Surface water responses

16 February 2021

**Re: Cowal Gold Operations Underground Mine Project Hydrological Assessment –
Response to DPIE Water and NRAR Comments**

**Figure 4.14 Predicted Annual Bland Creek Palaeochannel Borefield usage**

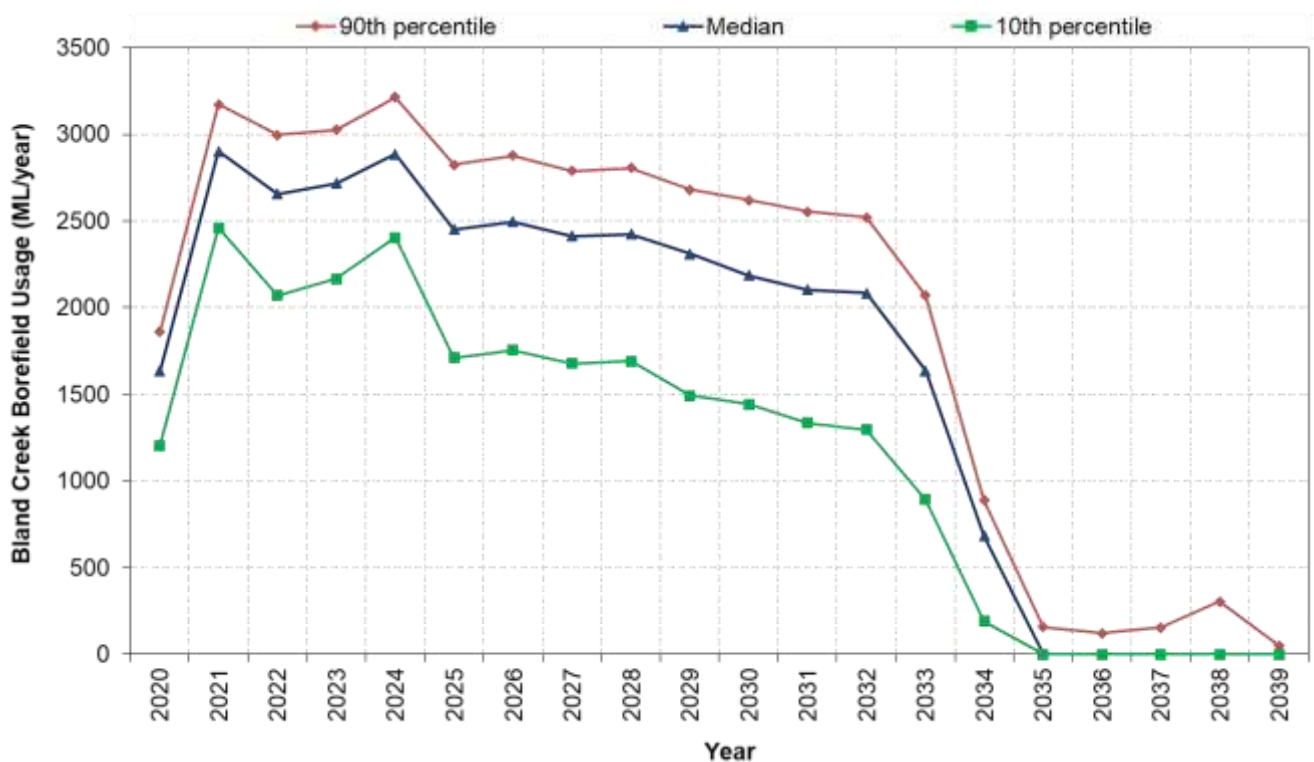
“90th percentile rainfall sequence (Dry) annual demand from the Bland Creek Paleochannel Bores to be approximately 3,700 ML/year (in year 2022). The proponent currently holds a licence with an entitlement of 3,650 ML/year” (DPIE Water and NRAR, 2021).

Figure 19 of Appendix G of the EIS (refer Figure 1 below) presents the water balance simulated 10th percentile, median and 90th percentile annual water demand / usage from the Bland Creek Paleochannel Bores. The 90th percentile annual volume is the demand / usage that was predicted not to be exceeded in 90% of the simulated 131 climatic sequences and the 10th percentile annual volume is the demand / usage that was predicted not to be exceeded in 10% of the simulated 131 climatic sequences. The percentile plots indicate predicted annual volume ranges between the 10th and 90th percentile risk or confidence limits / levels within which the predicted annual volumes could vary. The 90th percentile annual demand does not represent the annual demand / usage for the 90th percentile rainfall sequence, rather the 90th percentile annual demand / usage based on all 131 climatic sequences (model realizations) simulated. This is stated in the second paragraph of Section 6.2.2 of Appendix G of the EIS.

Figure 1 (Figure 19 of Appendix G of the EIS) illustrates that the annual demand from the Bland Creek Paleochannel Borefield is predicted to peak at 3,215 ML in 2024 based on the 90th percentile model results (calculated from all 131 simulated climatic sequences) and at 2,901 ML/year in 2024 based on the median model results (calculated from all 131 simulated climatic sequences). These annual volumes do not exceed the 3,650 ML/y held by the proponent.
